Please ask for: Ms Iqraa Malik
Email: iqraa.malik@terraquest.co.uk
Telephone: 01212341390
Our Ref: R/112/21/HH
Your Ref:
Date: 17th May 2021

Application for Planning Permission for Works or Extension to a Dwelling

Development: SINGLE STOREY SIDE EXTENSION AND LOFT CONVERSION WITH DORMERS

Location: 30 Chaucer Avenue Rustington BN16 2PQ

PROPOSED SITE PLAN - 1 : 500

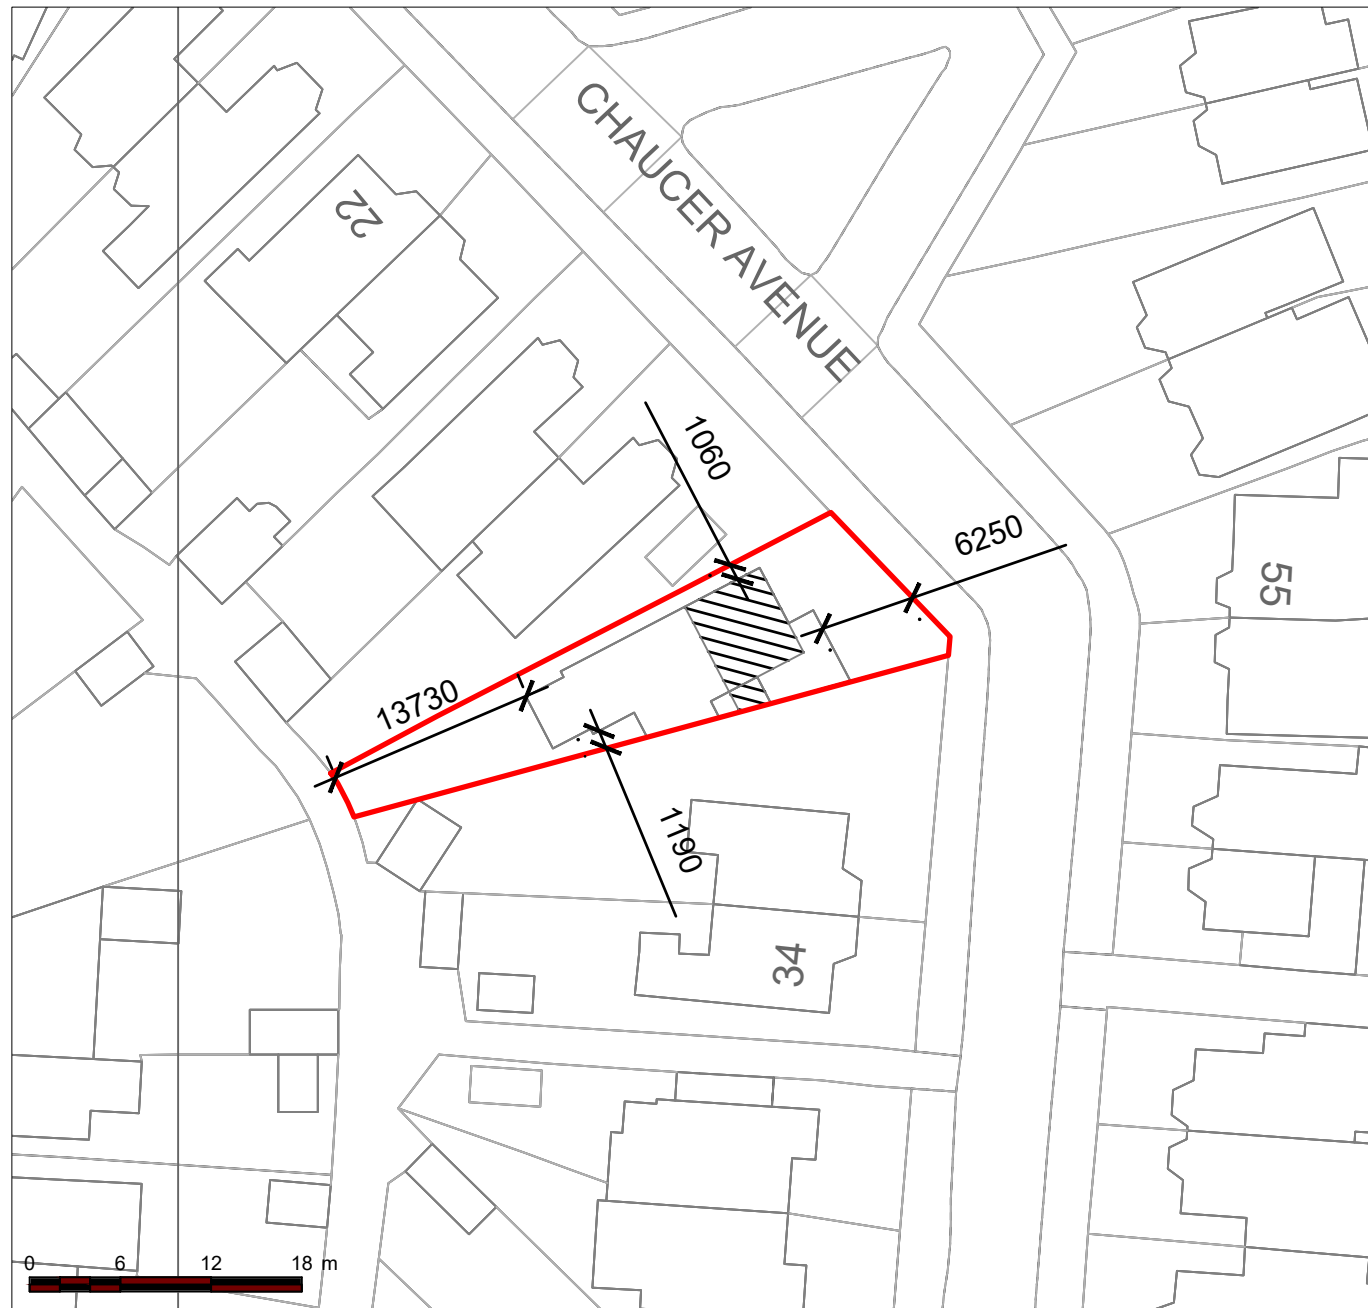
Dimensions: You are required to include dimensions on the block plan from the proposed extension to all site boundaries.
